OAKLANDS FARM SOLAR PARK

Non-Material Change Supporting Statement (EIA Addendum)

Document Ref: EN010122/NMC/1.1

Planning Inspectorate Reference	EN010122
Document Reference	EN010122/NMC/6.1
Author	Oaklands Farm Solar Limited

Document Ref: EN010122/NMC/2.3

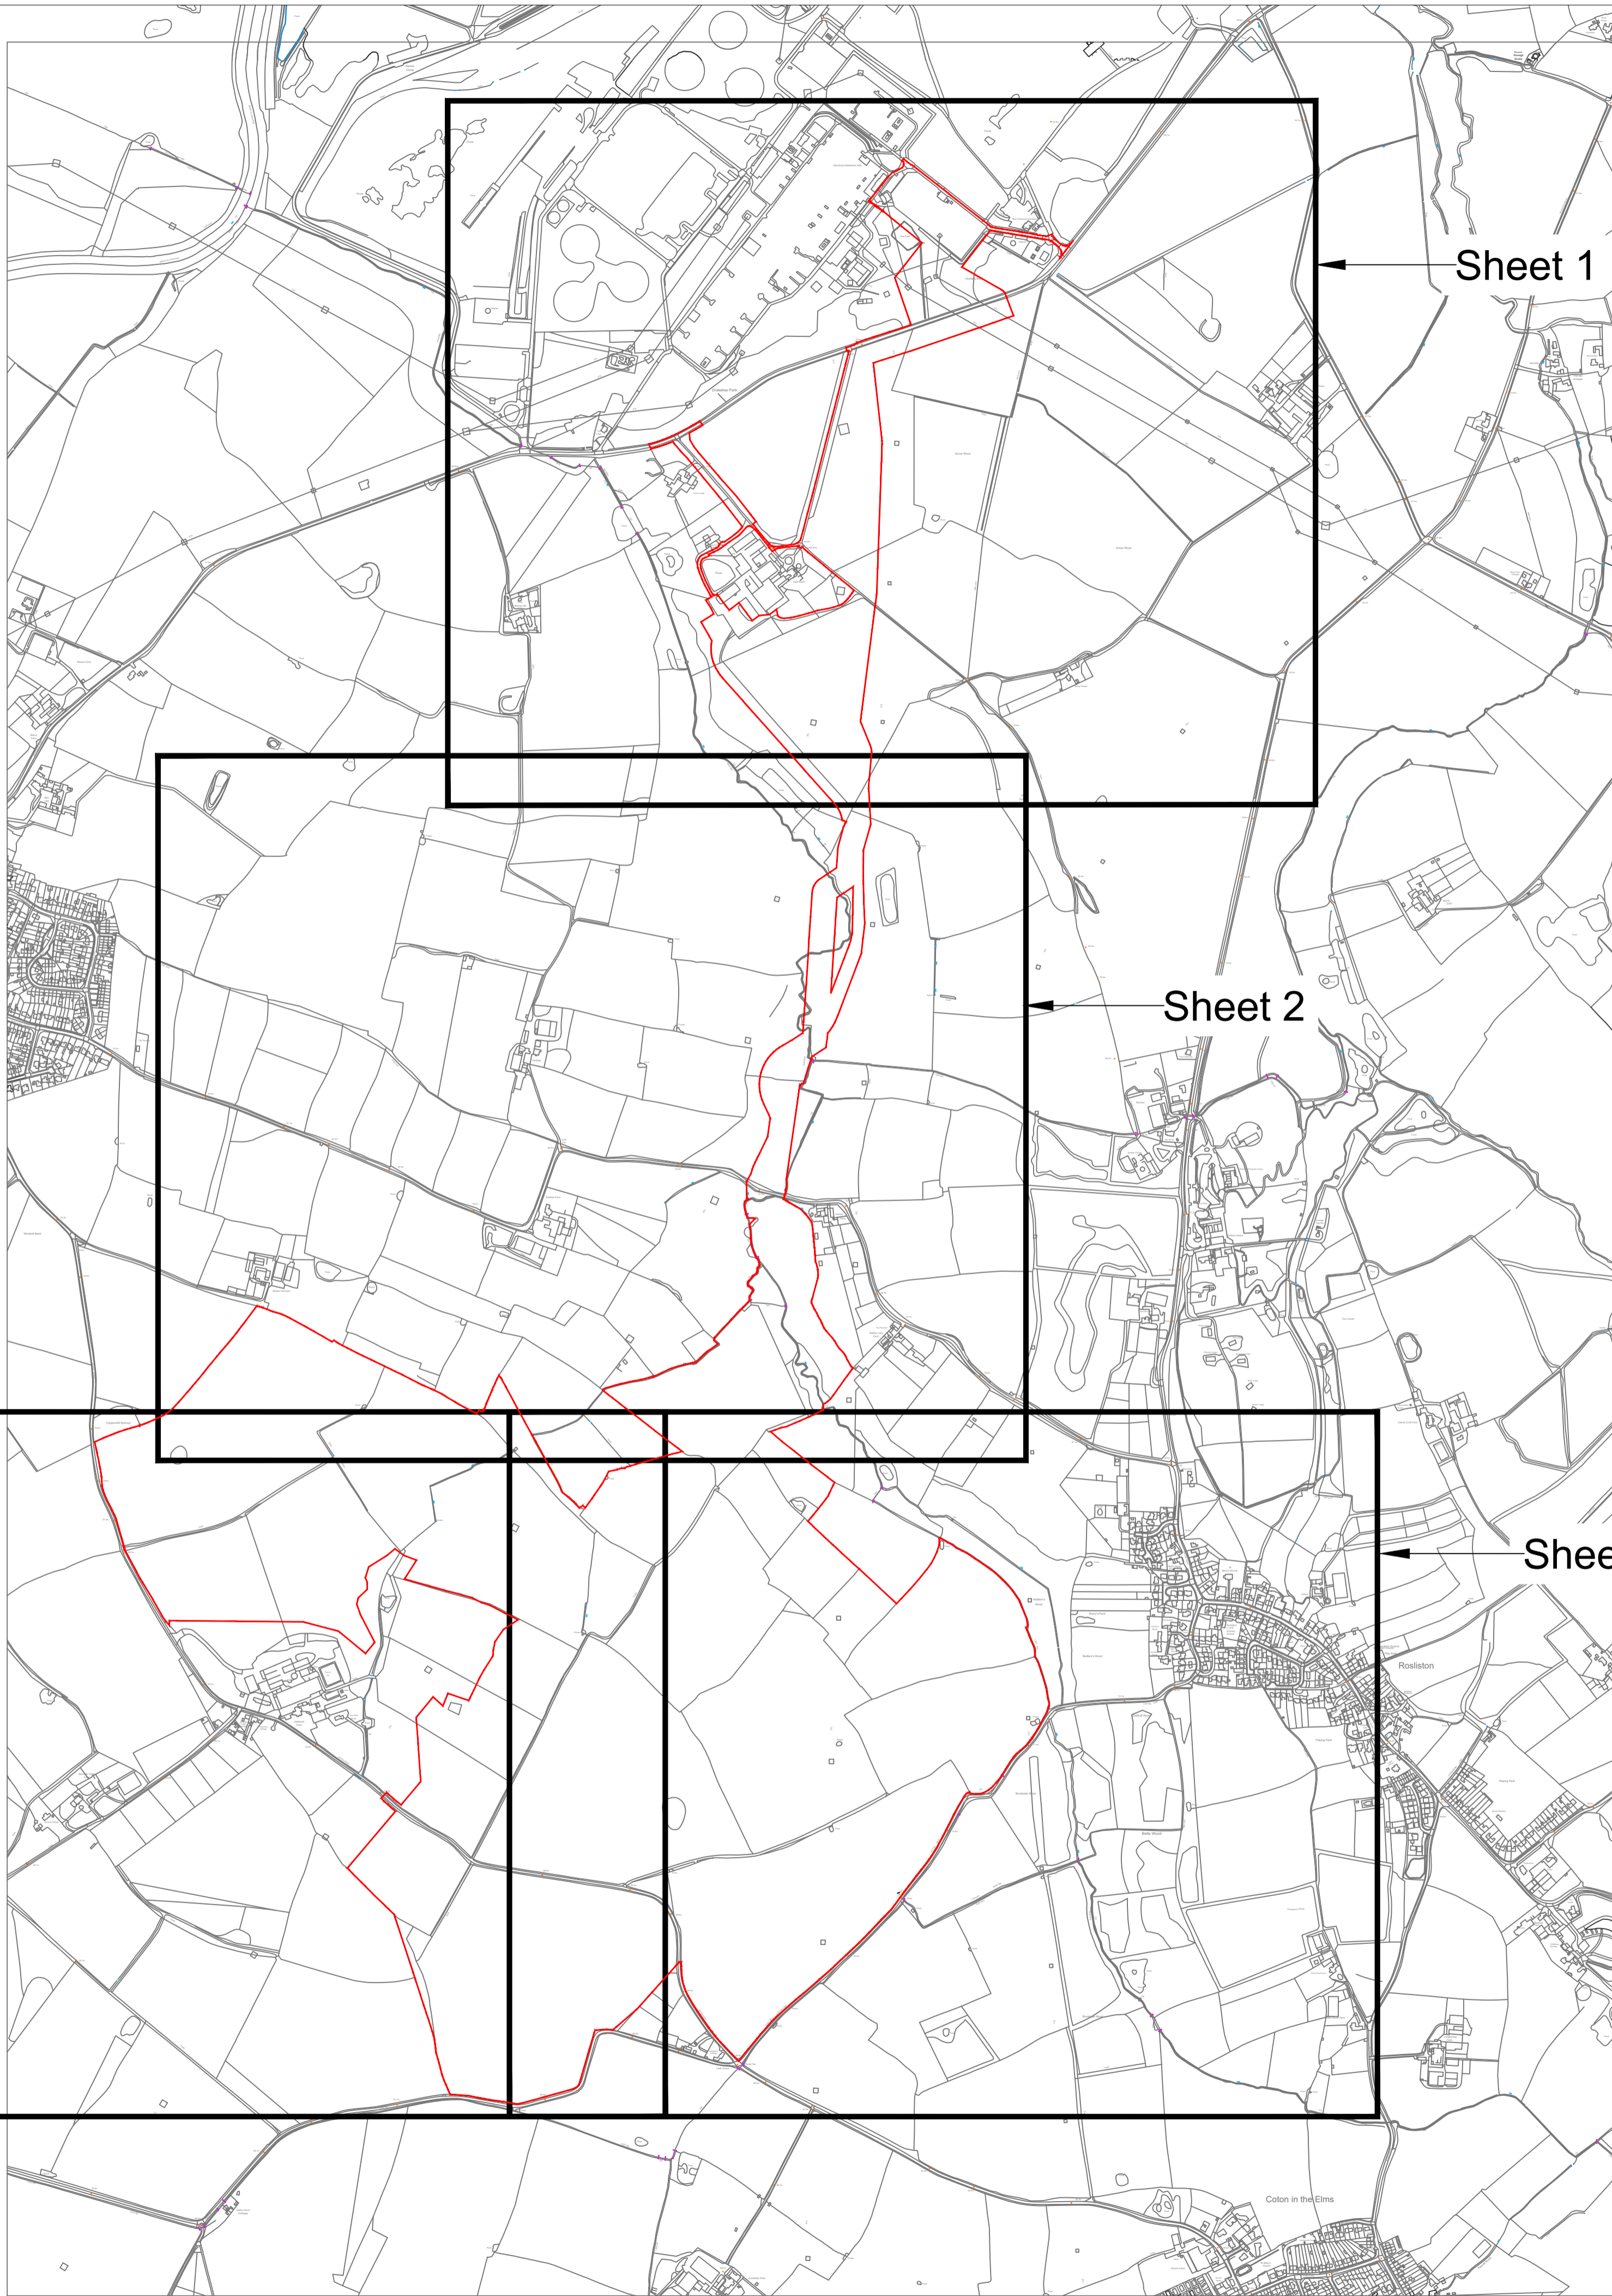
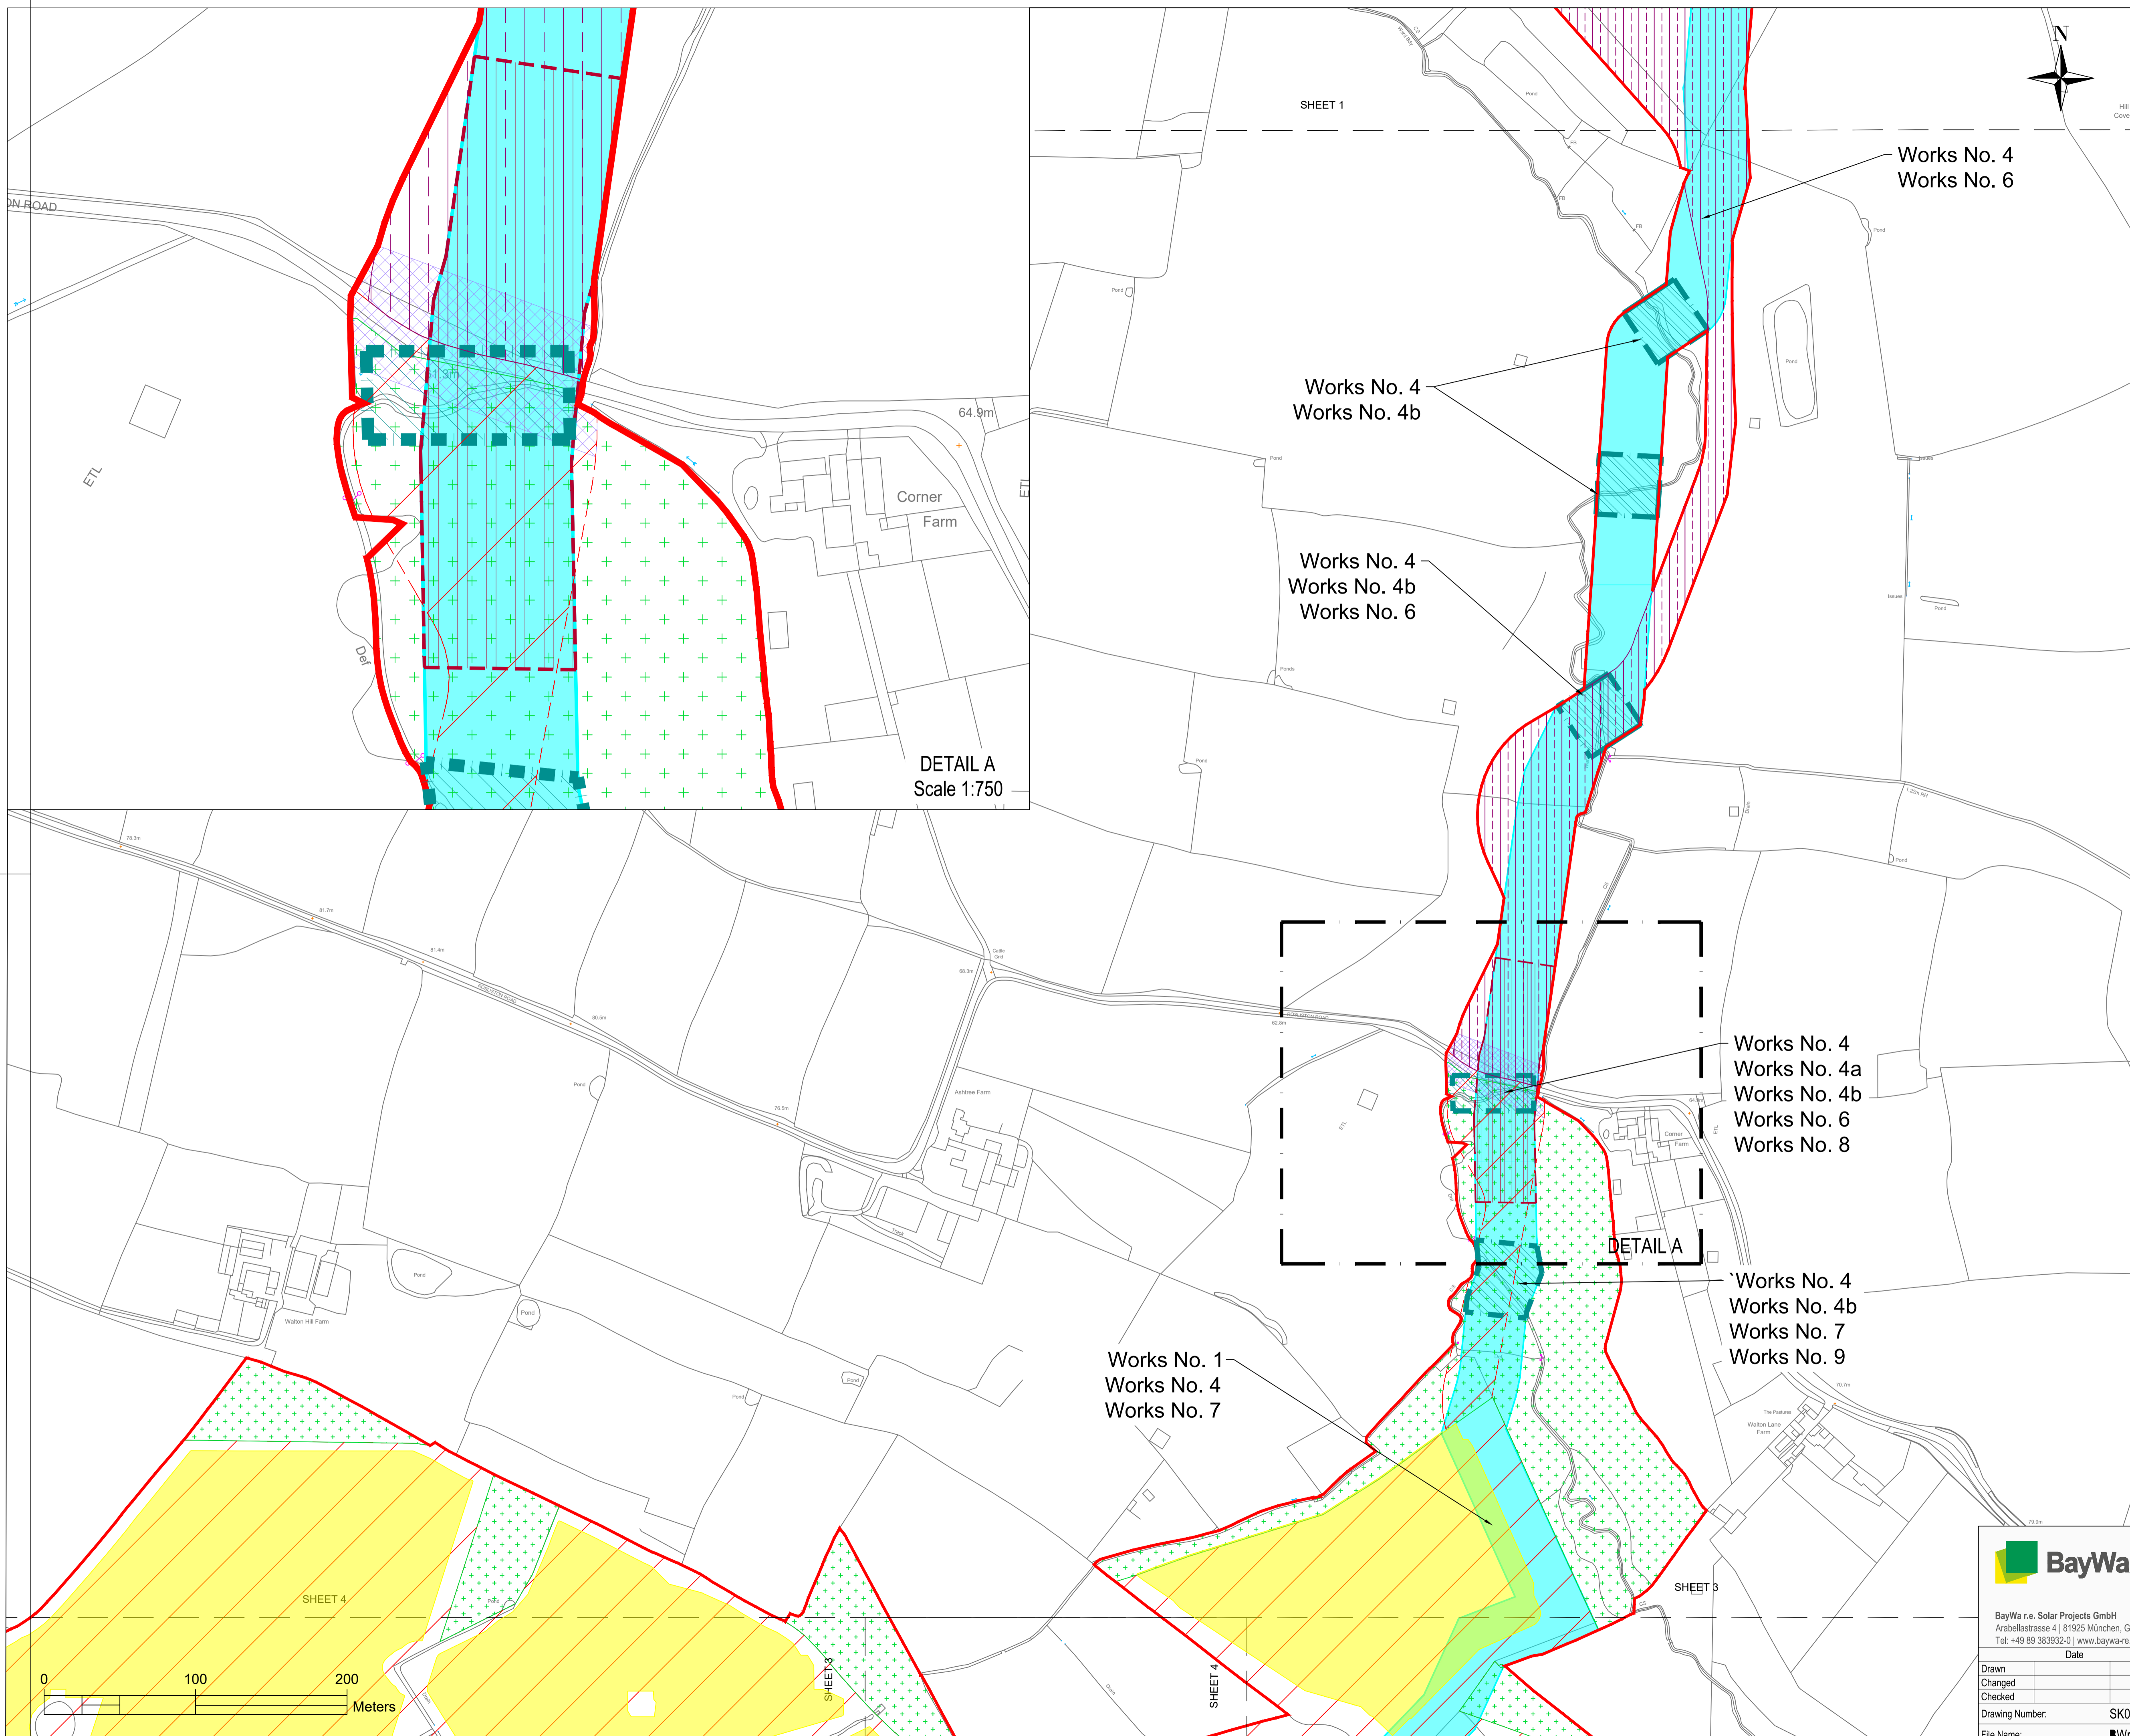
- 3.2.1 Through detailed procurement and design processes, the Applicant has been able to optimise the design by using newer technology. This primarily means the available land can be more effectively utilised to lay out the equipment to maximise efficiency and solar capacity. For example, more powerful inverter units can individually support a greater number of solar panel tables, and therefore more configurations of panel rows are possible to fit into irregularly shaped fields. Similarly, higher output solar panels mean the solar panel tables can be longer and therefore deployed more effectively in awkwardly shaped areas. To realise these optimisations, the Applicant proposes to slightly expand the footprint of work no. 1 in specific areas as shown in Appendix A and the revised Work Plans (Ref: EN010122/NMC/2.3). In addition, through the detailed design process the Applicant has identified three small areas which can be removed from the work no. 1 parameter area comprising the entirety of field 010, part of field 020 and a small area in field 04. This is because it is impractical to install solar panels in these areas due to the topography. The new amended area for work no. 1 along with an indicative solar panel layout is provided at Appendix A.

- 3.2.2 A Comparison Plan between the existing work no. 1 area and the proposed work no. 1 area is attached at Appendix B which highlights where the areas of work no. 1 have been extended and removed. This clearly shows that the proposed expansion accords with the general footprint of the Proposed Development. The Applicant considers the extensions are minimal, resulting in an overall increase of only 3.4% in the parameter area of work no. 1. Therefore, this change is non-material.

- 3.2.3 The revised Works Plan (ref. EN010122/NMC/2.3) captures the amendments to the parameter area of work no. 1.
